Our ref: SL/2018/118397/04-L01
Your ref: EN010093
Date: 20 May 2019

WRITTEN REPRESENTATIONS.

**Application by Cory Riverside Energy for an order granting development
consent for the Riverside Energy Park - Riverside Energy Park, Belvedere,
South East London**

Written Representations on behalf of the Environment Agency

Project Number:	172067	Zone:	DC	Level:	XX	Type:	XX	Disc:	SK	Number:	C	Revision:	111
-----------------	--------	-------	----	--------	----	-------	----	-------	----	---------	---	-----------	-----

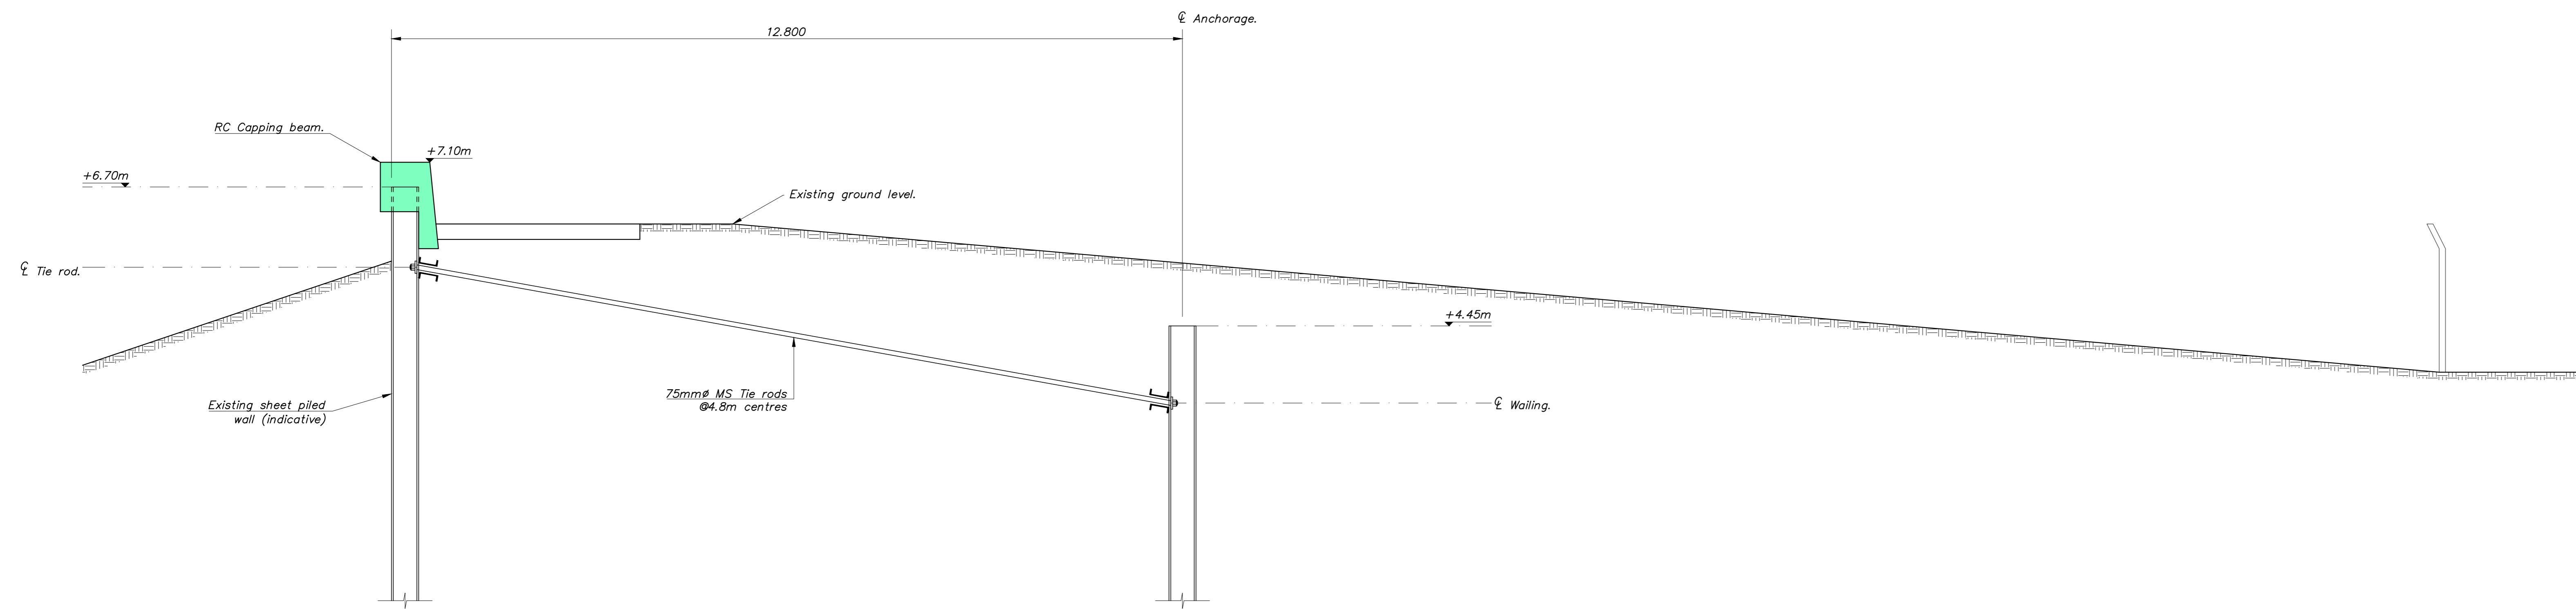
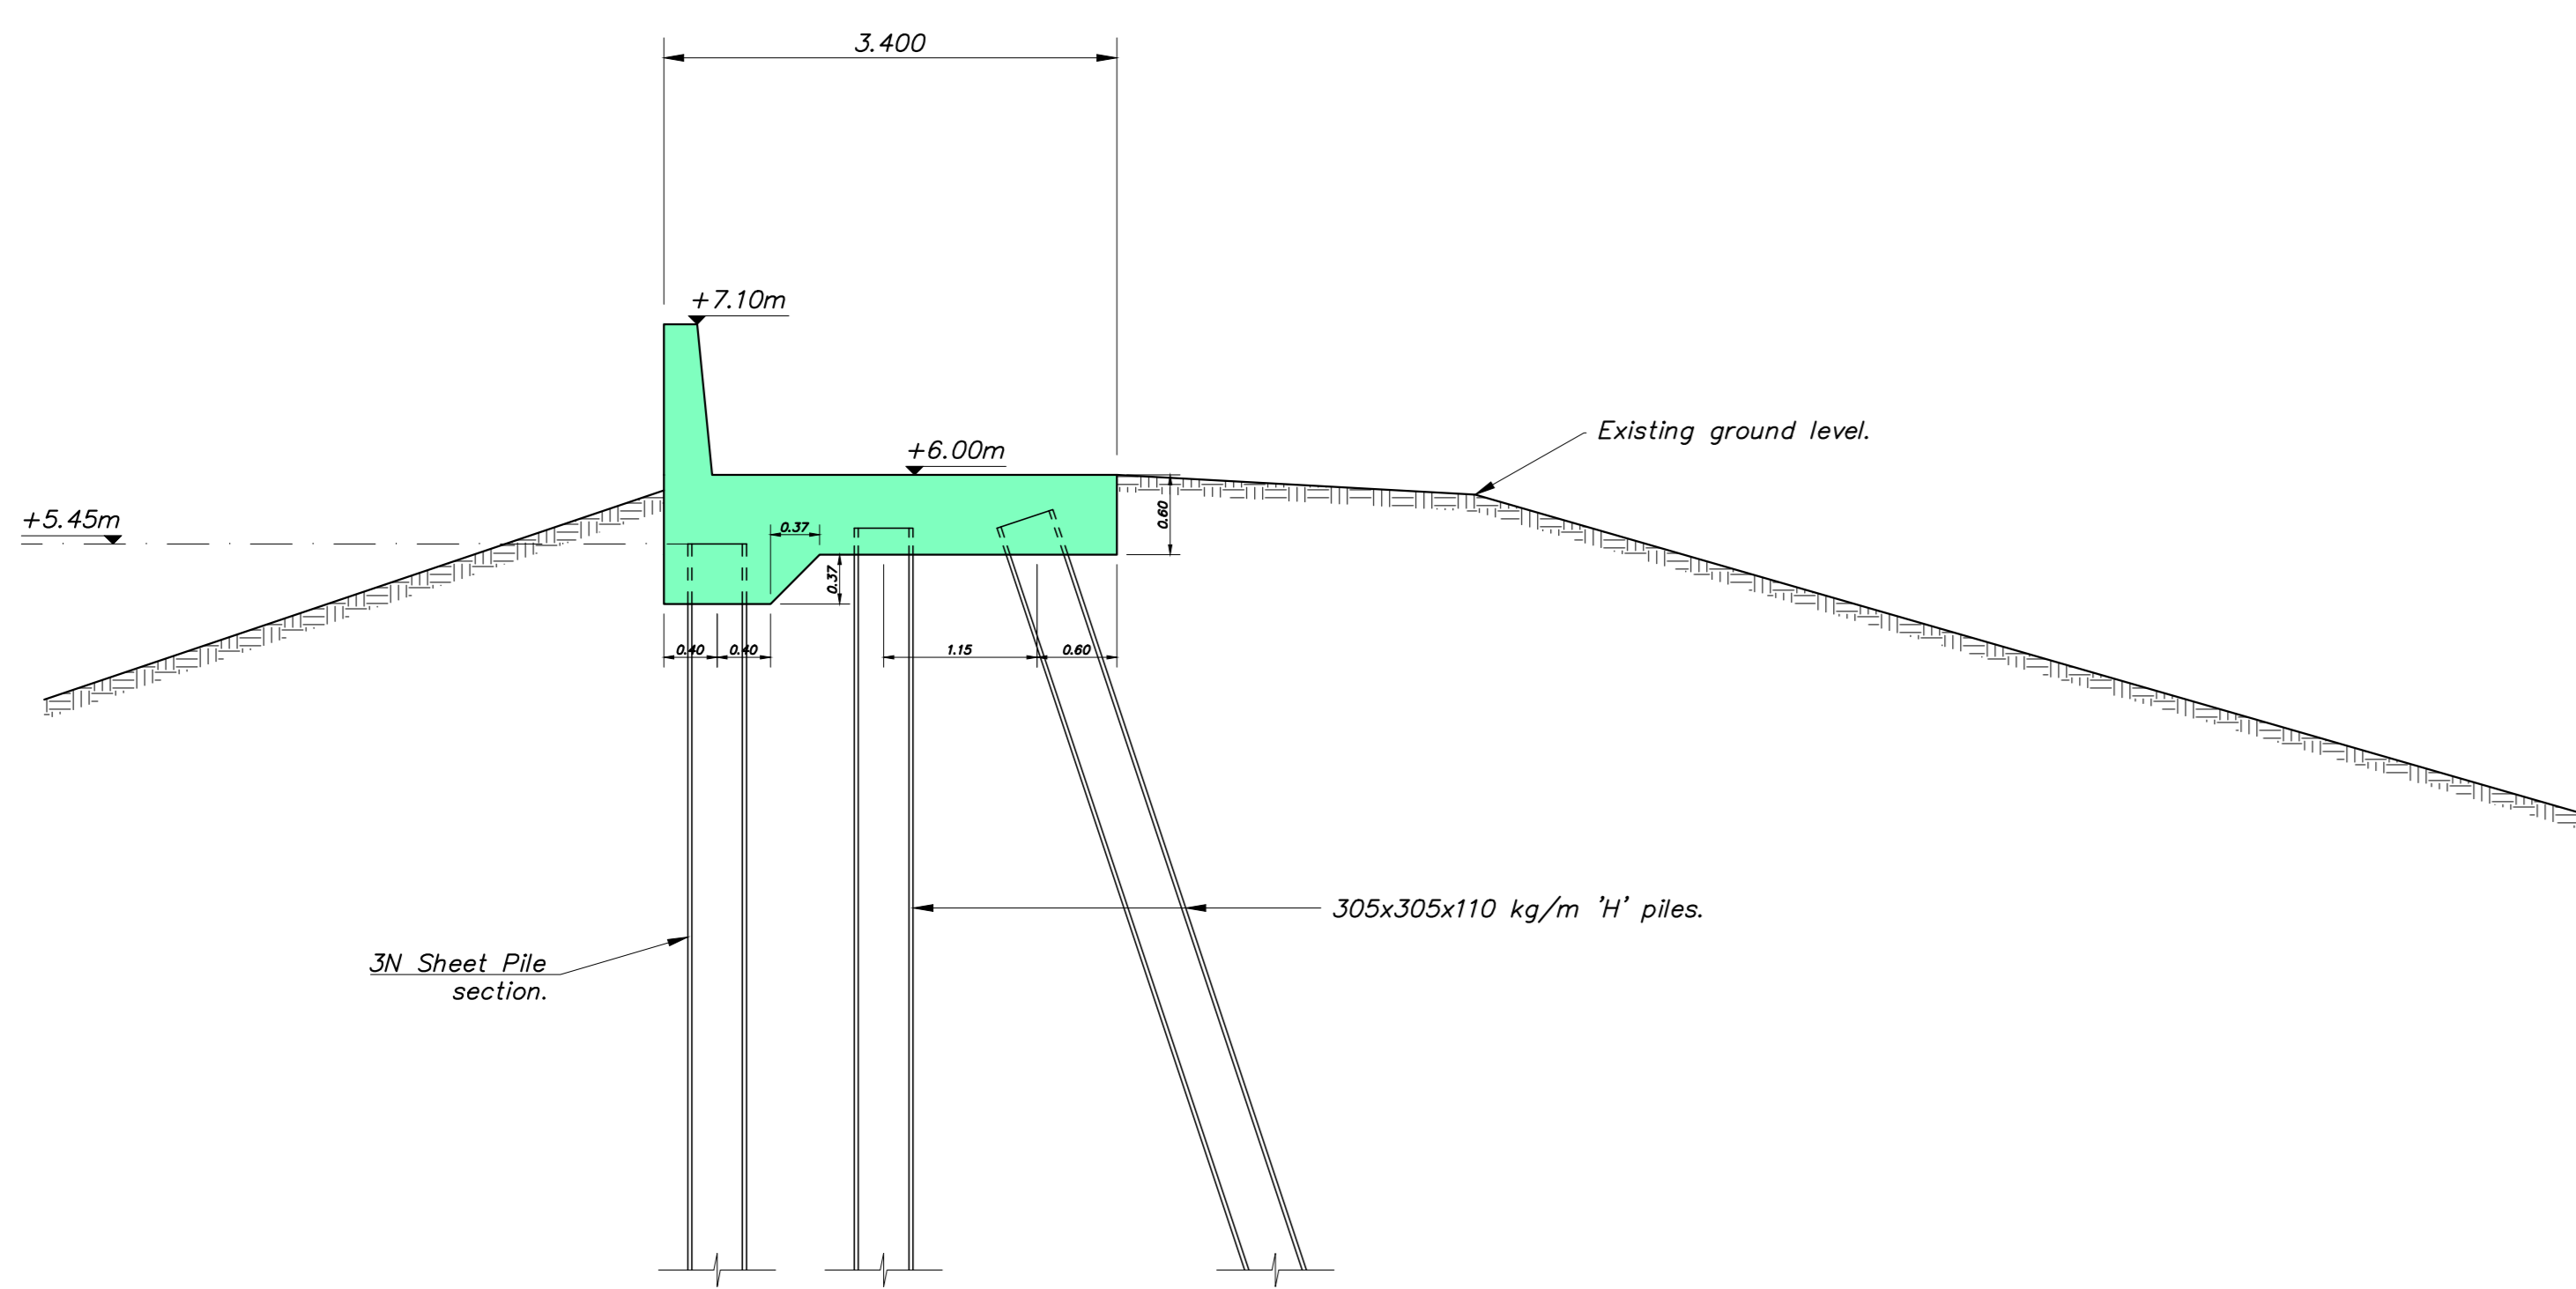
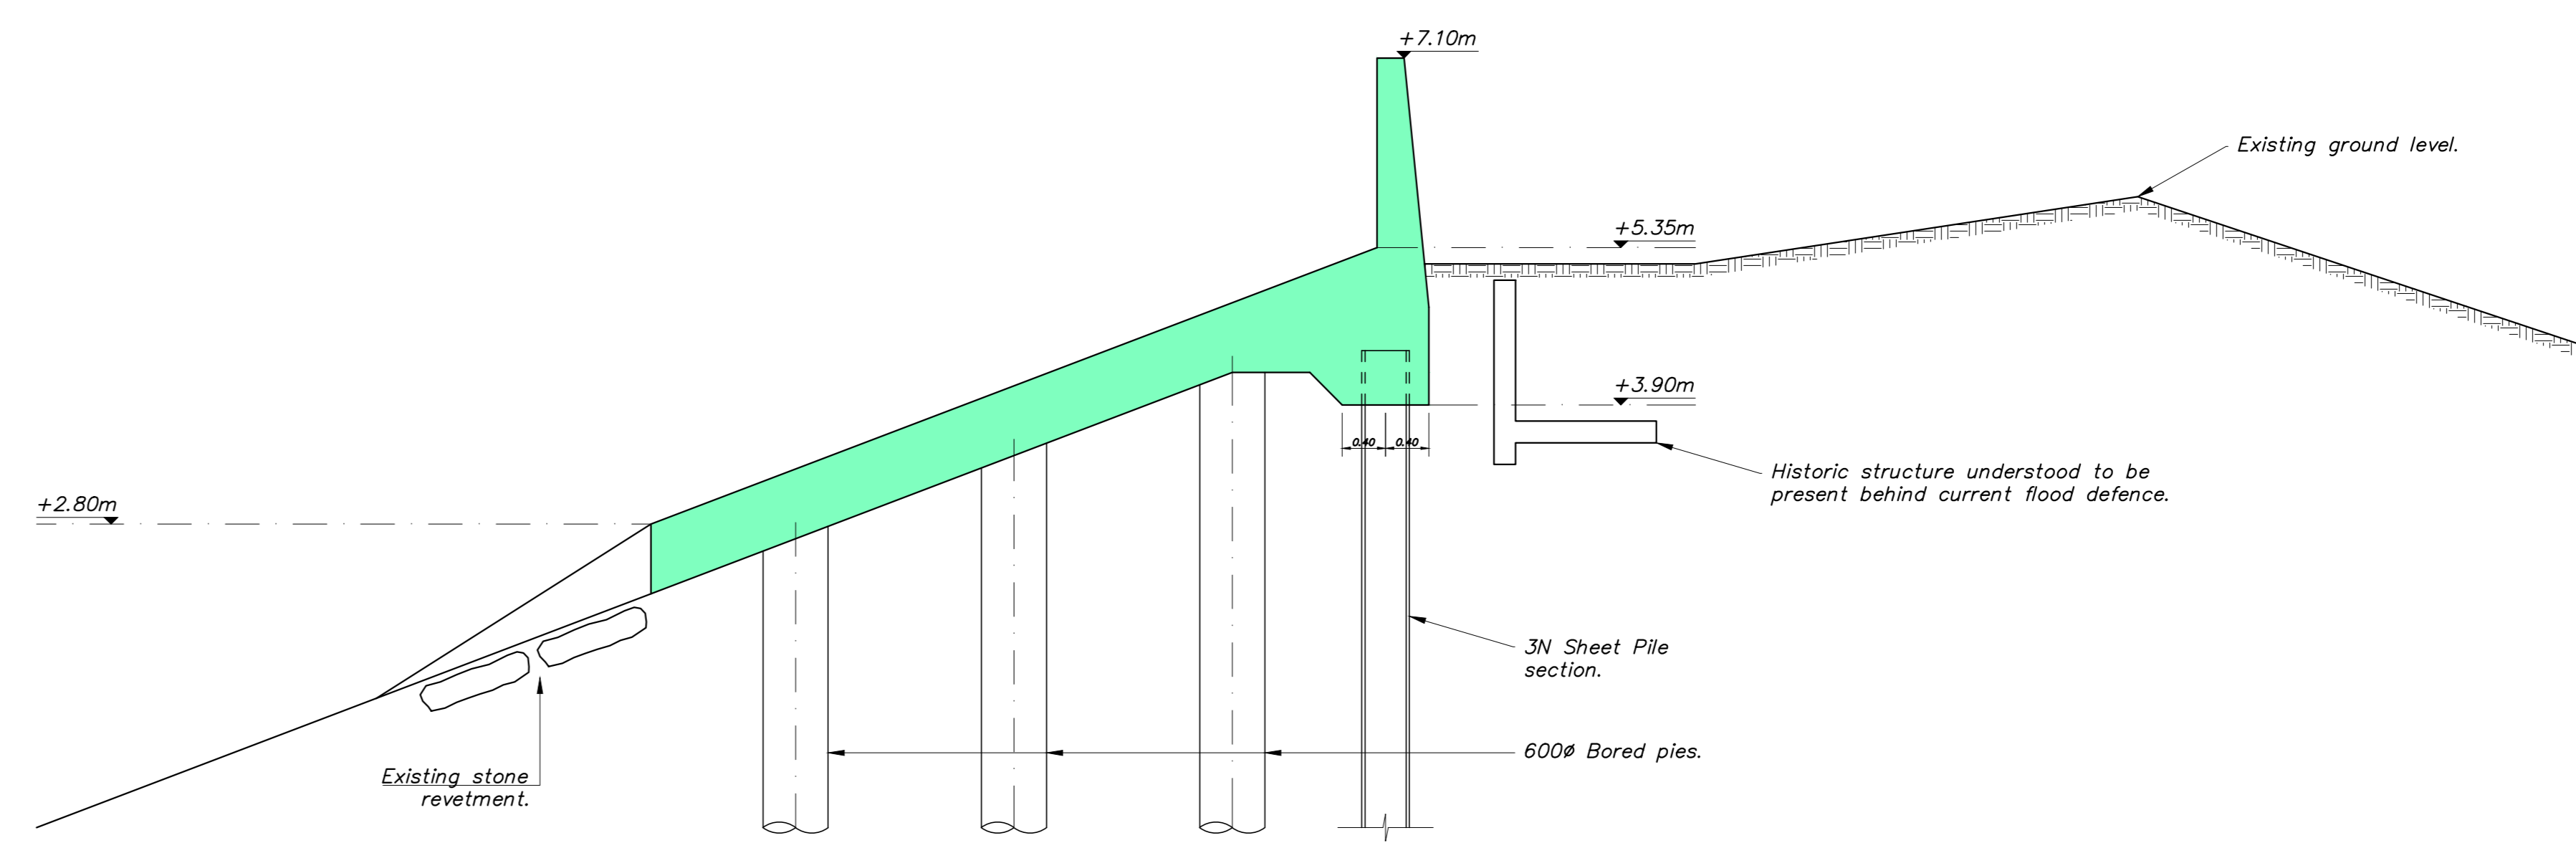
We have reviewed these drawing and are satisfied that it has been demonstrated that future raisings in line with the Thames Estuary 2100 Plan are possible once the REP has been constructed. These drawings are indicative to demonstrate that raising will be possible and do not necessarily reflect the scheme that will be implemented in the future. These drafts which are currently marked as draft should be submitted in support of the draft DCO.
